Job No: IAC-446

17 April 2016

**HEALTH INFRASTRUCTURE
LEVEL 6, 77 PACIFIC HIGHWAY
NORTH SYDNEY NSW 2060**REFERENCE: NSW FORENSIC PATHOLOGY AND CORONERS COURT
DOCUMENTATION REVIEW
ATTENTION: MR AARON SMITH

Drawing Number: SD-003

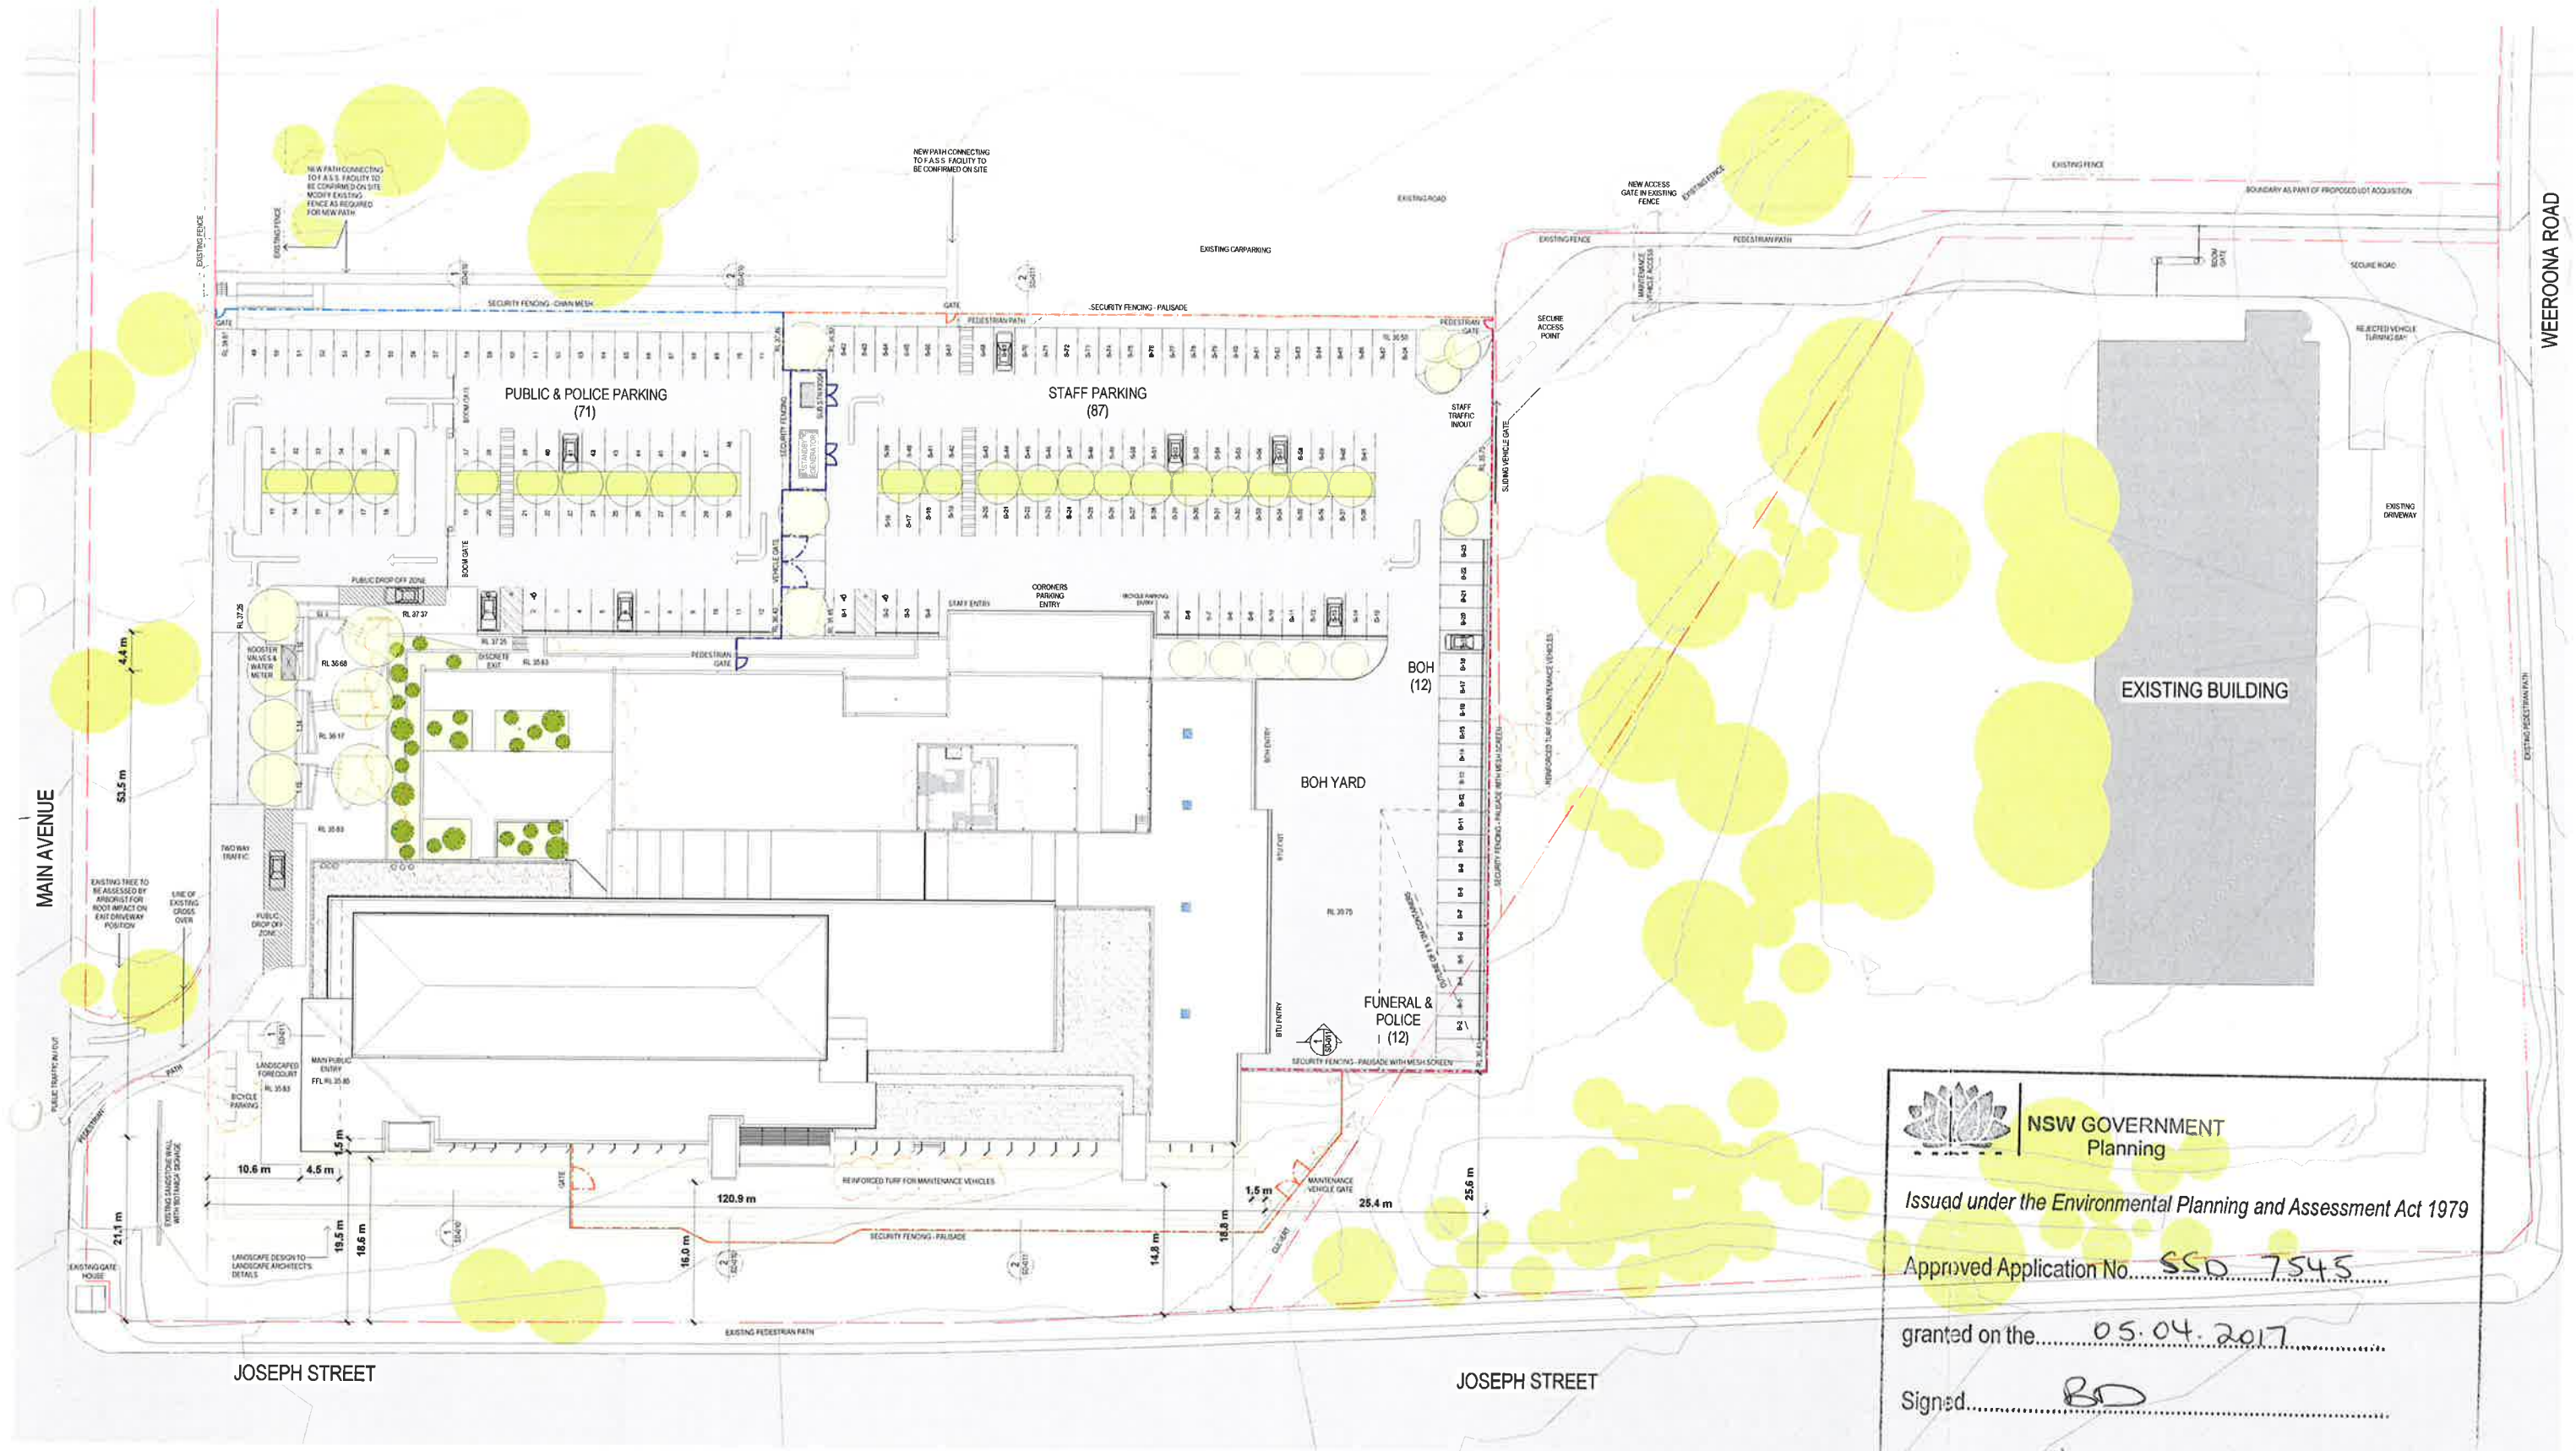
Documentation Review				
No	DWG No	Room	Discussion	Action
1.	SD-003		What is the gradient of the ramp immediately adjacent to the public drop off zone?	Item to be developed under design development.

2.	SD-003		Is the roadway at the same level as the pavement at the public drop off point?	Level.
3.	SD-003		<p>If the drive and pavement are at the same grade, then TGSIs and bollards will need to be nominated along the length of the drop off zone.</p>  <p style="text-align: center;">DIMENSIONS IN MILLIMETRES</p> <p style="text-align: center;">FIGURE 2.5 (B) APPLICATION OF WARNING TGSIs TO DEFINE THE PEDESTRIAN WAY FROM A CARRIAGEWAY IN ASSOCIATION WITH BOLLARDS</p>	Noted. Item to be developed under design development.

4.	SD-003		If there is a kerb separating the pavement and the roadway, then a kerb ramp compliant to Clause 10.7 of AS1428.1:2009 will need to be nominated to transition from the roadway to the pavement.	Noted. Item to be developed under design development.

No	DWG No	Room	Discussion	Action
5.	SD-003		 <p>Sharp transition at change of grade top and bottom of ramp</p> <p>Included angle between ramp surface and lower surface 166° min.</p> <p>Line of kerb</p> <p>Footpath</p> <p>Roadway</p> <p>Top landing 1500 min.</p> <p>1 in 8 kerb ramp 1520 max.</p> <p>Lower landing 1200 min.</p> <p>SECTION A-A</p> <p>Building line 2000 min.</p> <p>Direction of travel</p> <p>1500 min.</p> <p>Landing 1500 min. from top of ramp to any obstruction</p> <p>Upper landing</p> <p>1520 max.</p> <p>45°</p> <p>Kerb Ramp 1 in 8 max.</p> <p>45°</p> <p>Kerb face</p> <p>Lower landing</p> <p>1200 min.</p> <p>Vehicular way</p> <p>Direction of travel</p> <p>1000 min.</p> <p>PLAN</p> <p>Kerb face</p> <p>Sloping side</p> <p>Ramp</p> <p>ELEVATION B</p>	Noted. Item to be developed under design development.

Documentation Review				
No	DWG No	Room	Discussion	Action
6.	SD-003		<p>Should a wheelchair setdown zone be nominated. If so the parking zone for parallel parking will need to satisfy Clause 2.2.2 parallel parking of AS2890.6:2009.</p> <p>FIGURE 2.5 EXAMPLE OF A PARALLEL PARKING SPACE WITH SHARED AREA AT SAME LEVEL—DIMENSIONS FOR AUSTRALIA ONLY*</p> <p>DIMENSIONS IN MILLIMETRES</p>	Noted. Item to be developed under design development.

Documentation Review				
No	DWG No	Room	Discussion	Action
7.	SD-003		<p>What is the gradient of the ramp connecting the entry to the Public Police parking area? It appears the gradient is not steeper than 1:20? Attention is directed to the detail of Clause 10 of AS1428.1:2009.</p> <p>Specific attention is directed to:</p> <ul style="list-style-type: none"> • Slip resistance of pavement finishes • Positioning of landings • Handrails and handrail extensions • TGSIs • Lighting (150 lx) 	1:20 is achieved. Item to be developed under design development.

8.	SD-003		<p>Parking spaces</p> <p>The line marking of the general parking spaces will need to satisfy the requirements of Clause 4.4 of AS2890.1:2004.</p> <p><i>Parking spaces other than those for people with disabilities shall be delineated by means of white or yellow lines 80 to 100 mm wide, or white or yellow pavement markers in one or other of the forms and patterns illustrated in Figure 4.1 for angle parking or Figure 4.2 for parallel parking.</i></p>	Noted. Item to be developed under design development.

9.	SD-003		<p>Accessible parking spaces – Public & Police Parking</p> <p>The plan nominates 2 accessible parking spaces adjacent to the ramp connecting to the entry. The number of parking spaces satisfies the requirements of NCC Clause D3.5.</p> <p>The line marking of the accessible parking space will need to satisfy the requirements of Section 3 of AS2890.6:2009. Refer to attached technical sheet for line marking details.</p>	Noted. Item to be developed under design development.

10.	SD-003		<p>Accessible parking spaces – Staff Parking</p> <p>The plan nominates 1 accessible parking space adjacent to the staff entry. The number of parking spaces will need to be reviewed against the requirements of NCC Clause D3.5. A total of 111 staff parking spaces are provided. NCC Table D3.5 requires for NCC Building Classifications Class 5 and Class 9b that accessible parking be provided at the rate of 1 space for every 100 parking spaces. In this instance the accessible parking spaces provided will need to be increased by 1 parking space to satisfy this requirement. There is no impact on the parking arrangements in satisfying this requirement.</p> <p>The line marking of the accessible parking space will need to satisfy the requirements of Section 3 of AS2890.6:2009. Refer to attached technical sheet for line marking details.</p>	Noted. Item to be developed under design development.

Documentation Review				
No	DWG No	Room	Discussion	Action
11.	SD-003		Kerb ramps will need to be provided to connect the roadway to the pavement path of travel to the entry.	Noted. Item to be developed under design development.

12.	SD-003		What is the detail of the security fencing, gates and pedestrian access between the carparks?	Palisade fencing with a turnstile pedestrian gate.

13.	SD-003		What is the gradient of the vehicle ramp between the two carparks?	Refer to civil drawings
14.	SD-003		<p>Confirm that the gradients across the parking area satisfy Clause 2.4.6 of AS2890.1:2004.</p> <p>2.4.6.1 Maximum gradients</p> <p><i>The maximum gradients within a parking module including a motorcycle parking area shall be as follows:</i></p> <p>(a) Measured parallel to the angle of parking—1 in 20 (5%).</p> <p>(b) Measured in any other direction—1 in 16 (6.25%).</p> <p>(c) Within parking spaces for people with disabilities—see AS/NZS 2890.6*.</p> <p>2.4.6.2 Minimum gradients</p> <p><i>So that parking floors will drain adequately, the minimum gradient shall be 1 in 100 (1.0%) for outdoor areas and 1 in 200 (0.5%) for covered areas.</i></p>	Confirmed. Item to be developed under design development.

15.	SD-003		<p>Confirm that the gradients of the accessible parking spaces satisfy the provisions of Clause 2.3 of AS2890.6:2009.</p> <p><i>Each parking space for people with disabilities and related walking and wheelchair unloading areas shall comprise a firm plane surface with a fall not exceeding 1:40 in any direction (1:33 if the surface is a bituminous seal and the parking space is out of doors). These areas shall have a slip-resistant surface.</i></p>	Confirmed. Item to be developed under design development.

16.	SD-003		Should there be parking spaces for motorcycles?	Advise is that parking of bikes would be minimal and can utilise carpark spaces.
